Table of Amendments to draft Development Consent Order

Part of DCO	Change	Reason
Deadline 2 (18 March 2020)		
Article 2 Interpretation: "Environmental Statement"	Date of submission version of Environmental Statement inserted.	Amended in response to the ExA's question ISH1.
Article 2 Interpretation	The definition of 'works plan' changed to 'works plans' for consistency with article 16.	Amended in response to the ExA's question ISH2.
Article 2(3) Interpretation	The words 'Requirement 14 (Detailed Design Approval) have been inserted before 'of Schedule 2'.	Amended in response to the ExA's question ISH3.
Article 2(4) Interpretation	The words 'Schedule 1 of' have been inserted after 'authorised by'.	Amended in response to the ExA's question ISH4.
Article 4(1) Effect on K3 planning permission	The word 'commence' has been replaced by 'start'.	Amended in response to the ExA's question ISH18 to avoid any confusion between the defined term 'commence' in relation to works, and 'commence' in relation to operational use.

Client **Wheelabrator Technologies Inc**
 Project **K3 and WKN DCO**
 Title **WKN Parameter Plan**

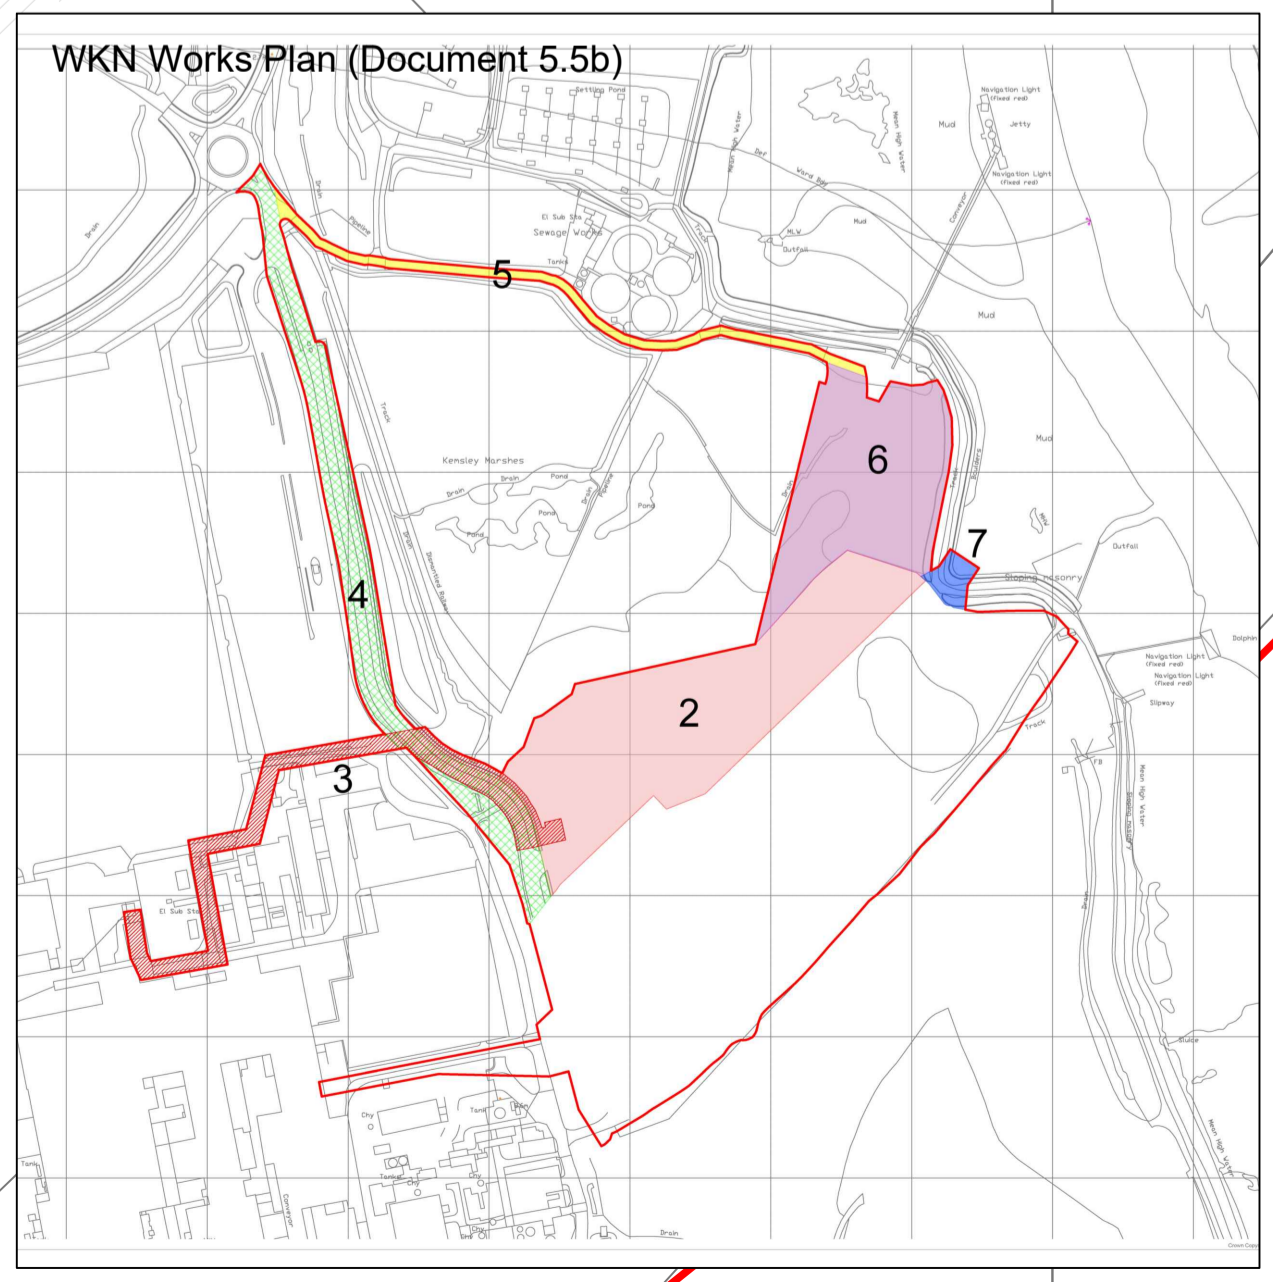
Schedule 2 Requirement 14(4) Detailed Design Approval	Duplication of "(4)" deleted. Definition of "WKN parameter plan" moved to requirement 1.	Amended in response to the ExA's question ISH30.
Schedule 2 Requirement 14 Detailed Design Approval – Table 1	The maximum height of Work No 2(j) Administration Office has been corrected to 30m to be consistent with Table 2.3 of the ES.	Amended in response to the ExA's first written questions 1.2.4.
Schedule 2 Requirement 16(4) Implementation and maintenance of landscaping	Reference to the 'annual landscaping maintenance plan' has been corrected to the 'approved landscaping scheme'.	Amended in response to the ExA's question ISH31.
